**RE: Primrose School at 4550 Paradise Blvd NW
Erosion and Sediment Control Plan - C13E029
Engineer's Stamp Date (6/5/25) SWQ-2025-00034**

Per the correspondence June 18, 2025, please find the following responses addressing the comments listed below:

| | <p>SHEET # SW-1</p> <p>JOB # 2017092</p> | |

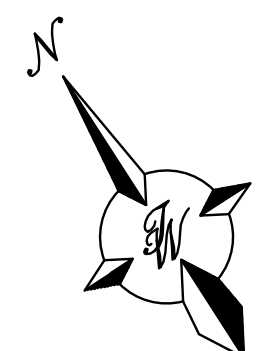
1. The limits of disturbance and area of disturbance must be modified to include the Work Order (WO) improvements in the public right-of-way north and south of this site as shown on the map on sheet SW-1, as identified in the table on sheet SW-2, and the "Estimated area to be disturbed" on the NOI. **The offsite areas are now included in the disturbed area. The NOI will be updated when the EPA releases a hold on it due to some additional information they've requested from the owner.**

3. Stormwater Silt Fence (SWSF) must be constructed on contour and may not be used to control concentrated flows. Nearly all of the silt fences (SF) shown on the ESC Plan aren't on contour, so they aren't effective as stormwater controls; however, they are effective as fugitive dust controls. The ST is the primary stormwater control to prevent sediment from leaving this site. SWSF is only appropriate for disturbed areas that can't be diverted into the ST. Add diversion berms downgradient from areas of disturbance to convey stormwater into the ST, where possible. **The site is lower than the surrounding property and streets and flows towards the pond at the east end. Diversion Dikes were added to the plan to ensure water is directed to the pond.**

application to the Stormwater Quality Section of the Planning Department, and they should be included in the SWPPP. Provide a specification on the ESC Plan for the disturbed areas not covered by the Landscape Plan or Work Order sheets and specify a "Landscape Buffer Swale" between the sidewalk and curb per COA DWG 2414. **The Landscape Plan was separated from the Erosion Control Plan set. The Landscape Buffer Swale note was added to SW-1.**

7. In addressing the comments, you will need to account for any upstream off-site stormwater that enters the sediment trap, as per CGP2.2.12.c. With the expansion of the "limits of disturbance" into the adjacent right-of-ways, especially Paradise Blvd, the existing and proposed drainage patterns (including the existing and proposed "Discharge Points") should be shown on the map, along with any existing and proposed storm drains. The drainage patterns must match the approved G&D Plan. **A diversion dike and inlet protection were added to Paradise Blvd. The drainage patterns do match the approved grading and drainage plan.**

8. A temporary diversion of upstream off-site flows around the areas of land disturbing activities in Paradise Blvd, if possible, may be preferable to adding volume to the ST for those flows. Temporary concentrated flow paths should be non-erosive to prevent exacerbating erosion problems on-site during construction. **A diversion dike and inlet protection were added to Paradise Blvd.**

| | <div>EROSION CONTROL NOTES</div> | <div>DATE</div> <div>6-24-25</div> |

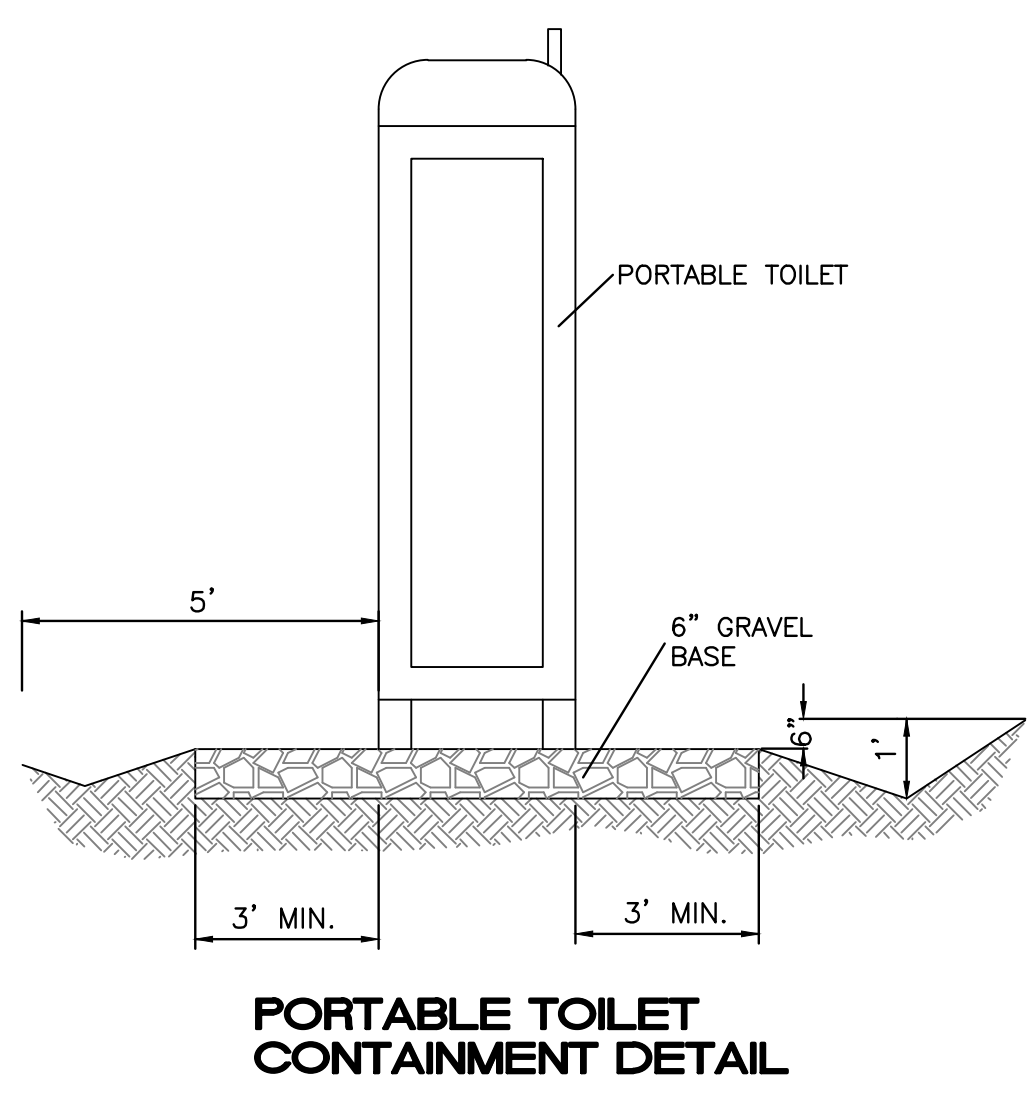
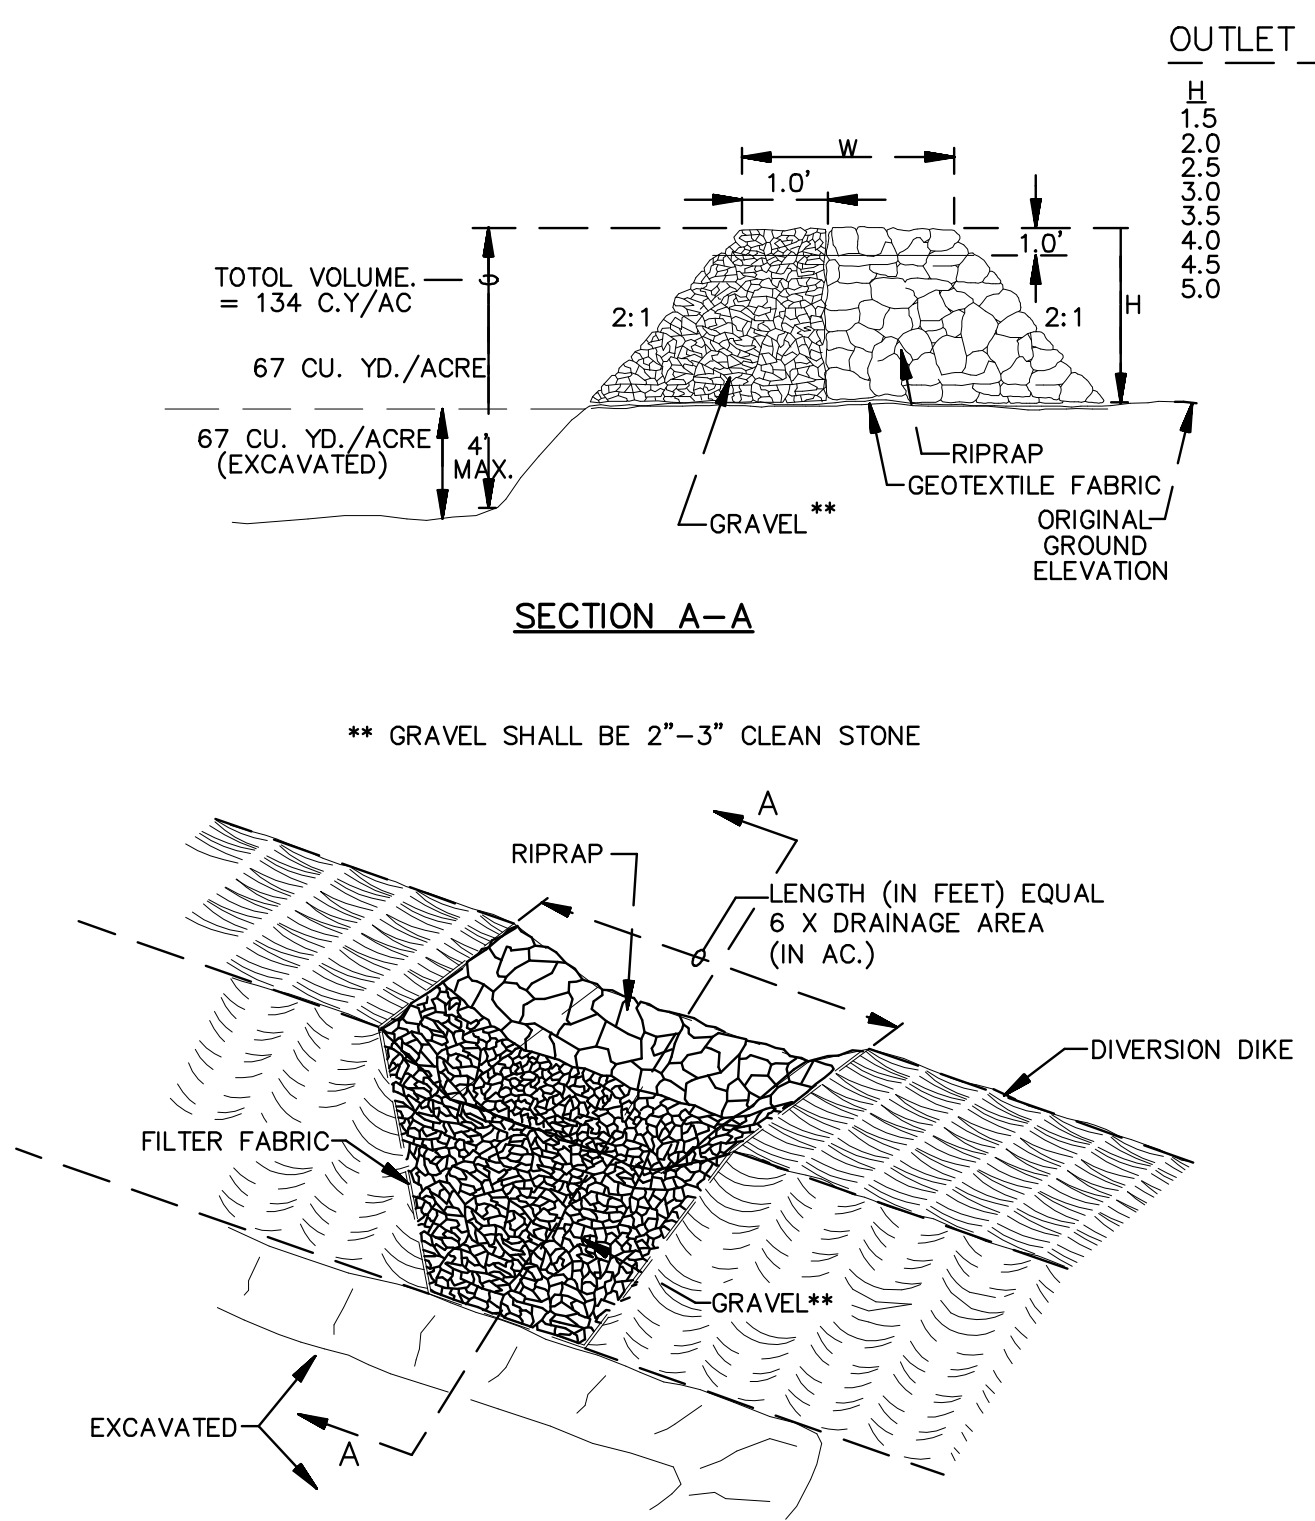
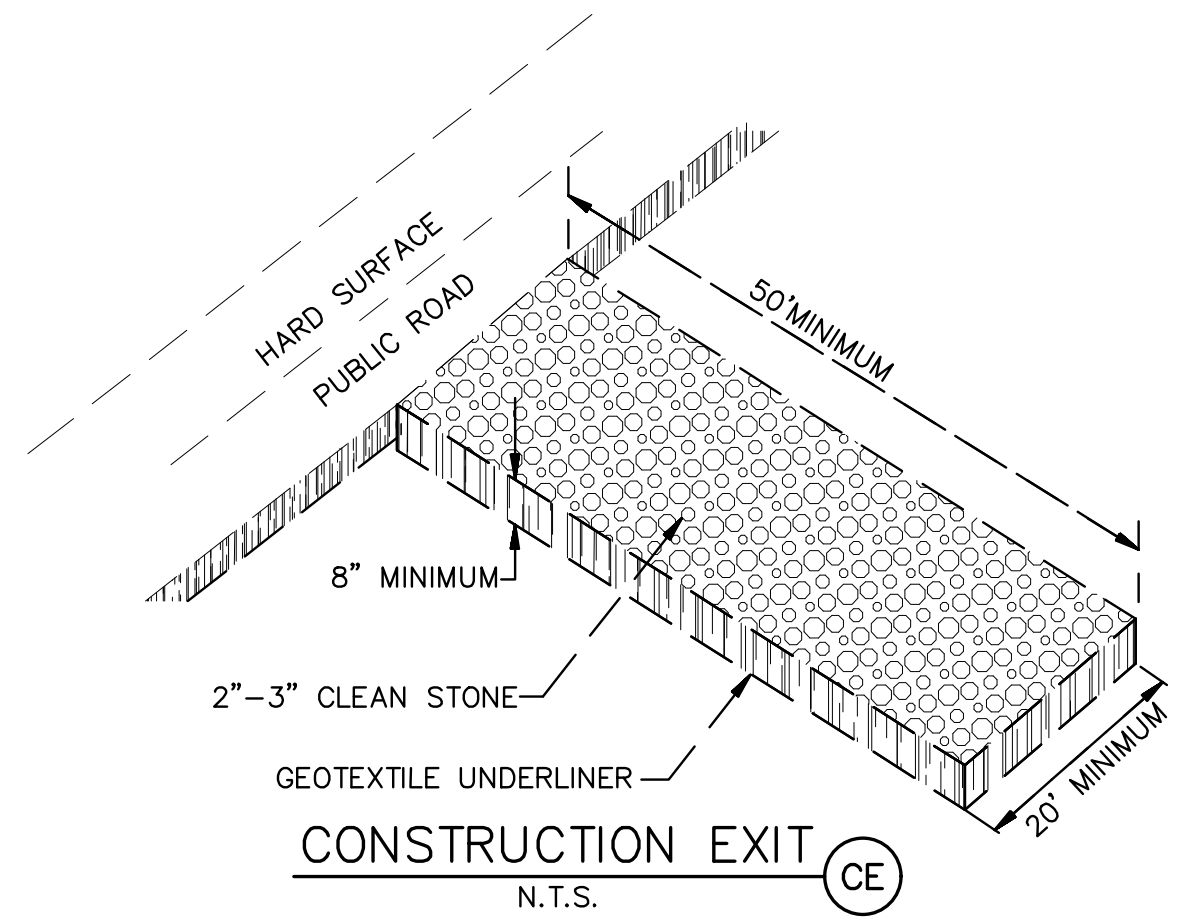
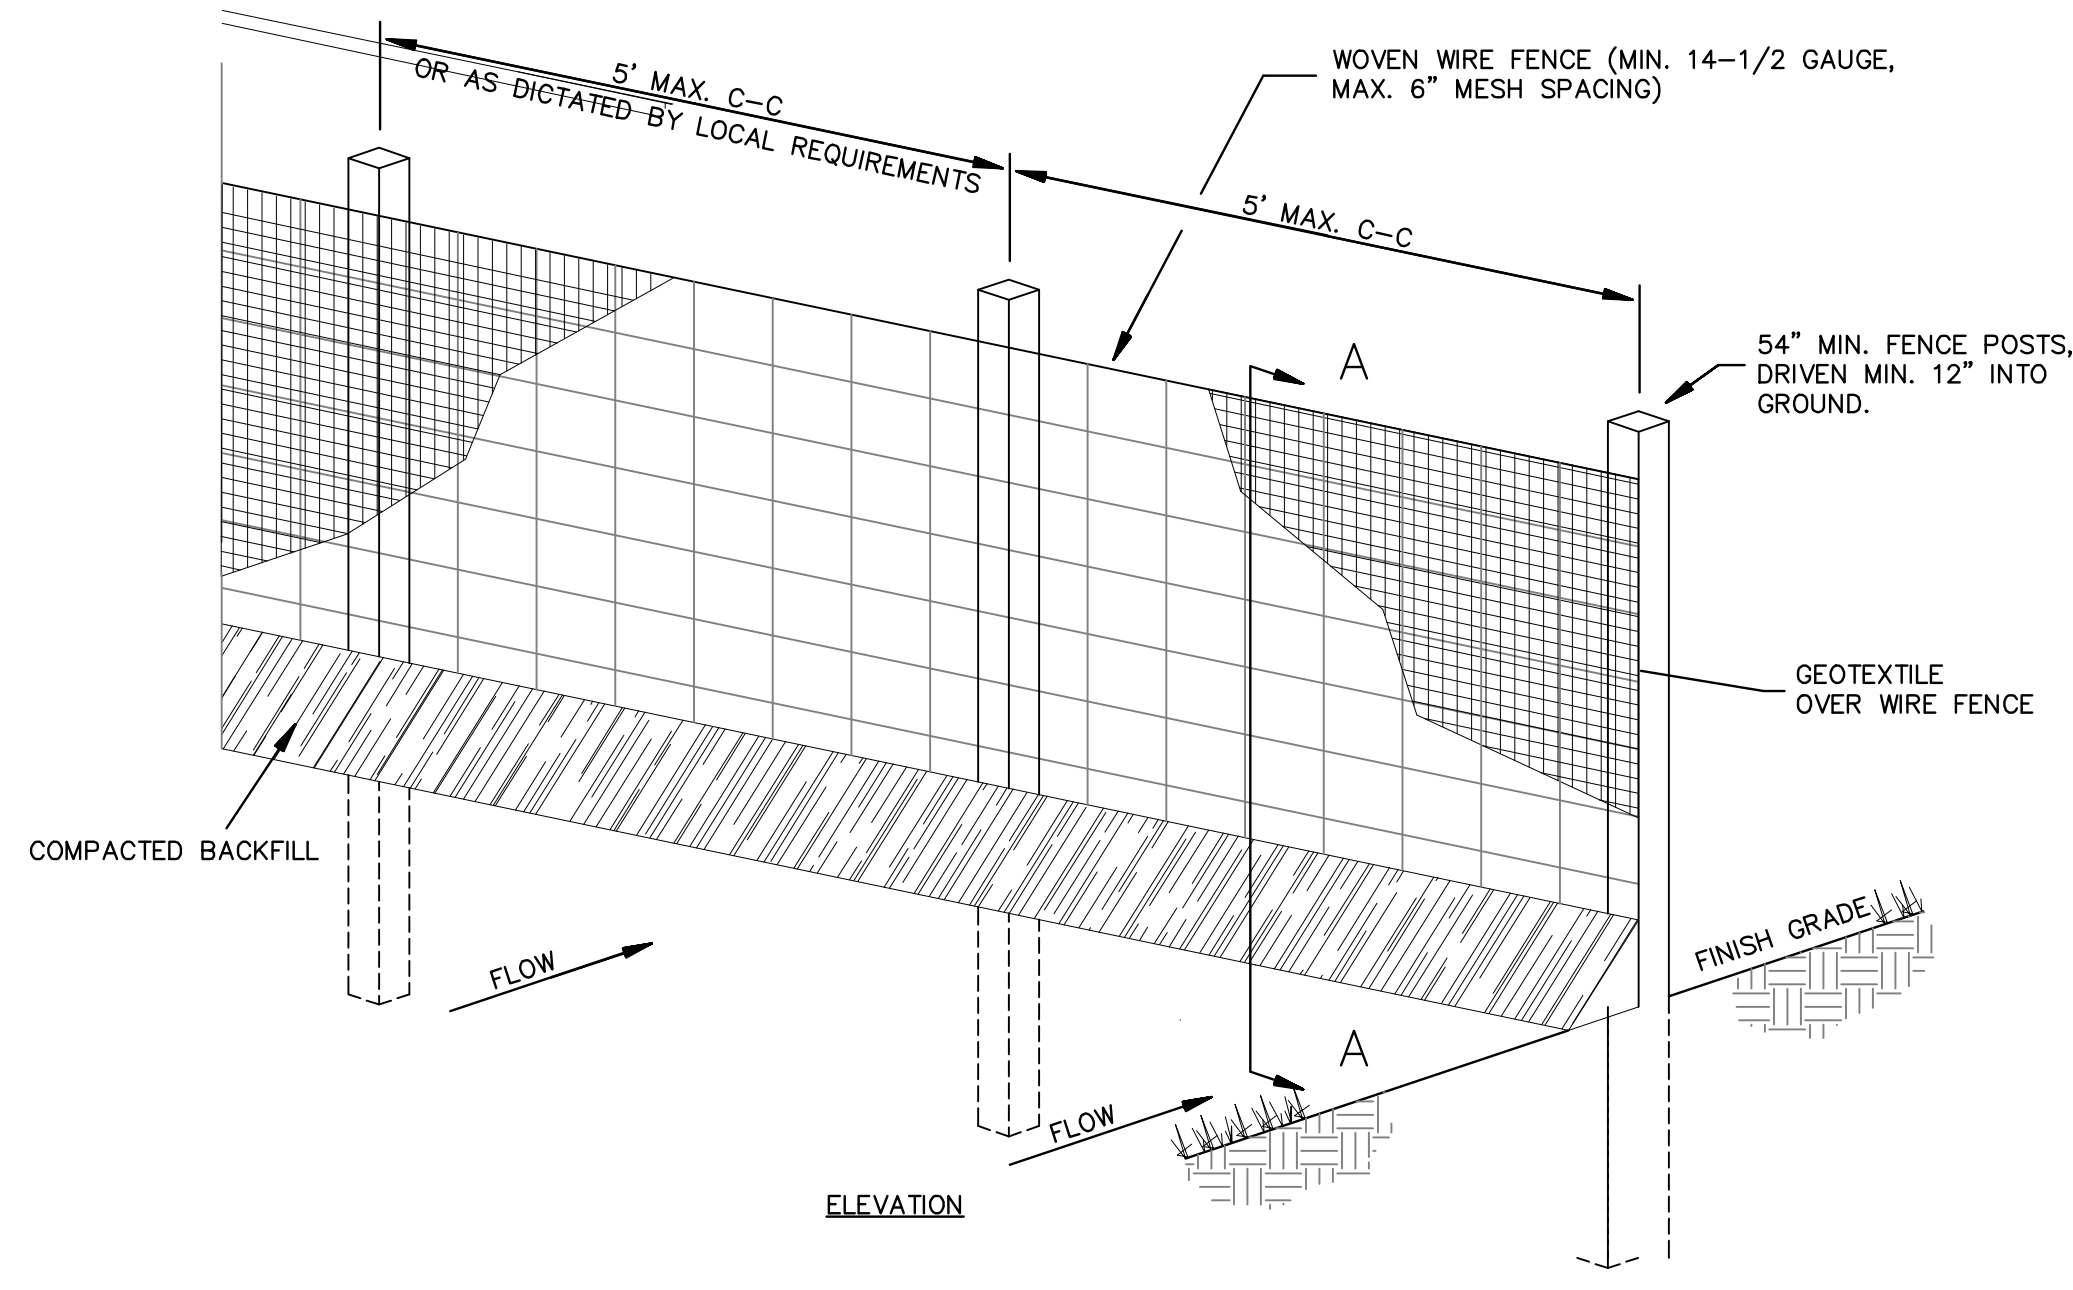
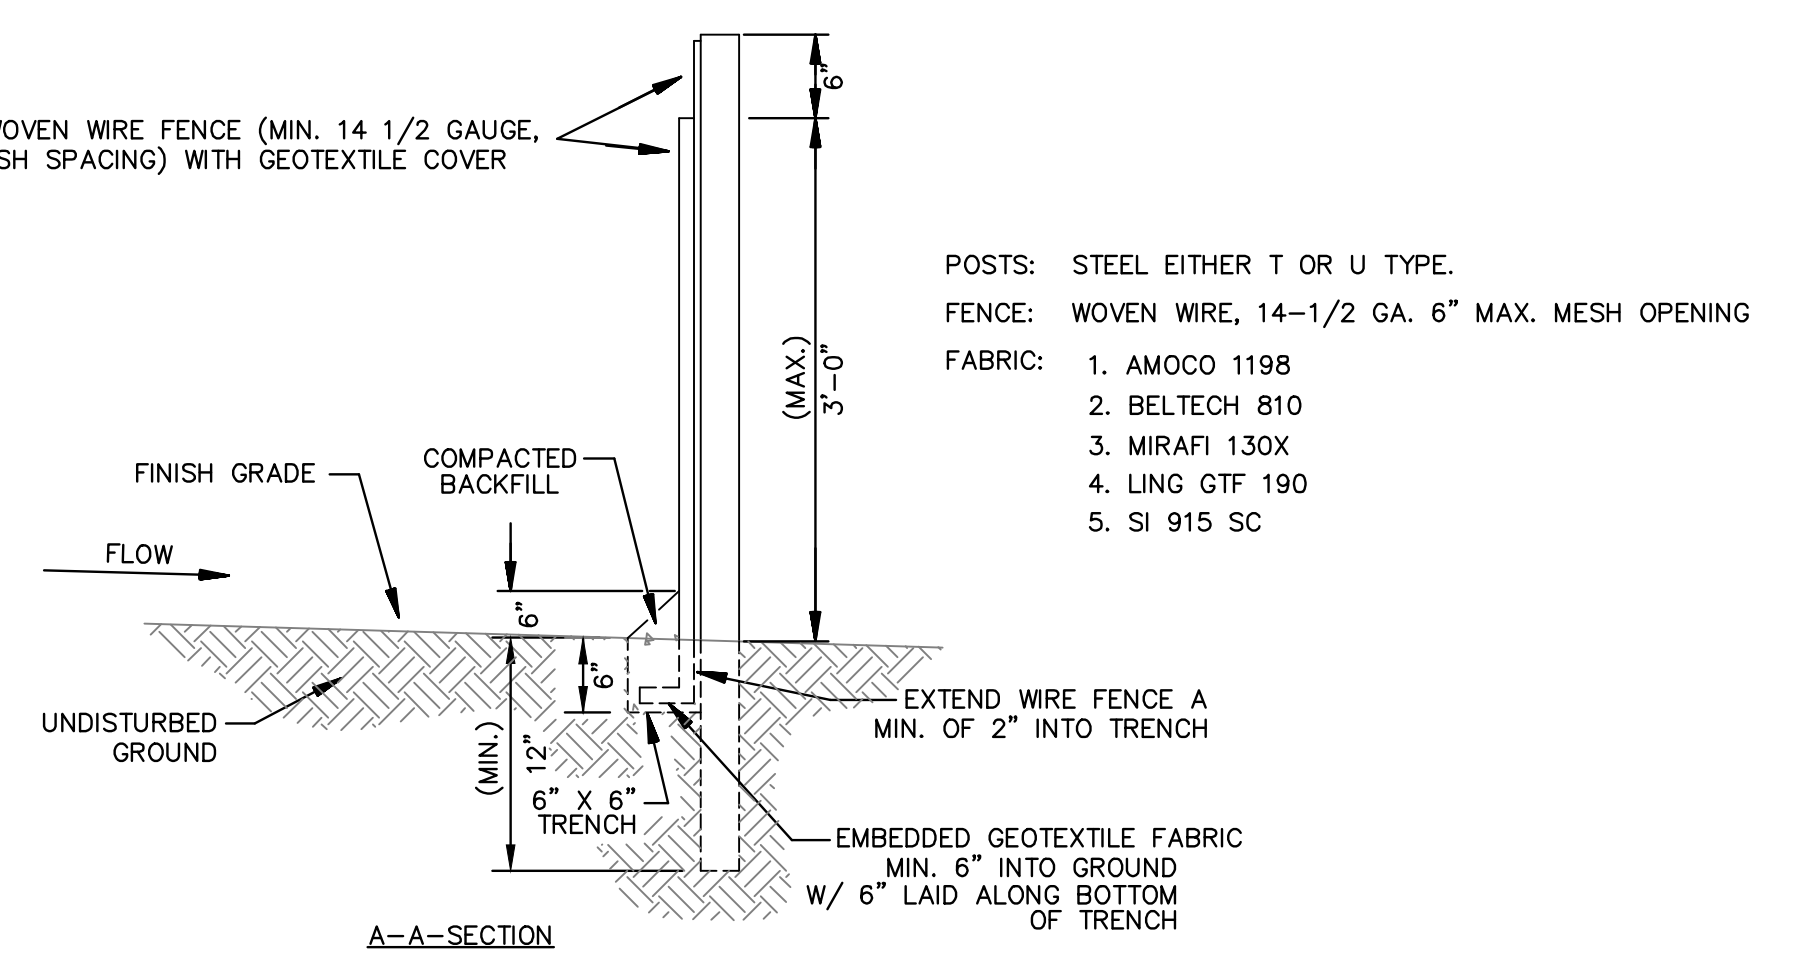
2. It appears that the ST is undersized. Provide design calculations and specifications for the temporary Sediment Trap per CGP 2.2.12.c. If a retaining wall is required to construct the south embankment of the ST and the outlet, provide construction specifications and clearly identify the wall as one of the first items of construction before clearing and grading. Clearly label the contours and dimensions of the temporary ST. Provide hydraulic calculations, sections, and construction specifications for the temporary non-erosive outlet structure per CGP 2.2.12. d and e. **The desilting ponds were updated to account for 1,800 cubic feet per acre of disturbance. The volume of each pond is noted on the plan.**

5. Update the city's Standard Notes on sheet SW-2. **These notes were updated.**
6. Update the engineer's stamp date each time the plan changes. **The stamp date was updated.**

9. Several temporary and permanent swales need to be identified in the "Sequence of Construction". **The sequence of construction was updated to include the temporary diversion dikes.**

10. Where is the medical building mentioned in the "Sequence of Construction"? **This was an old note that was deleted.**
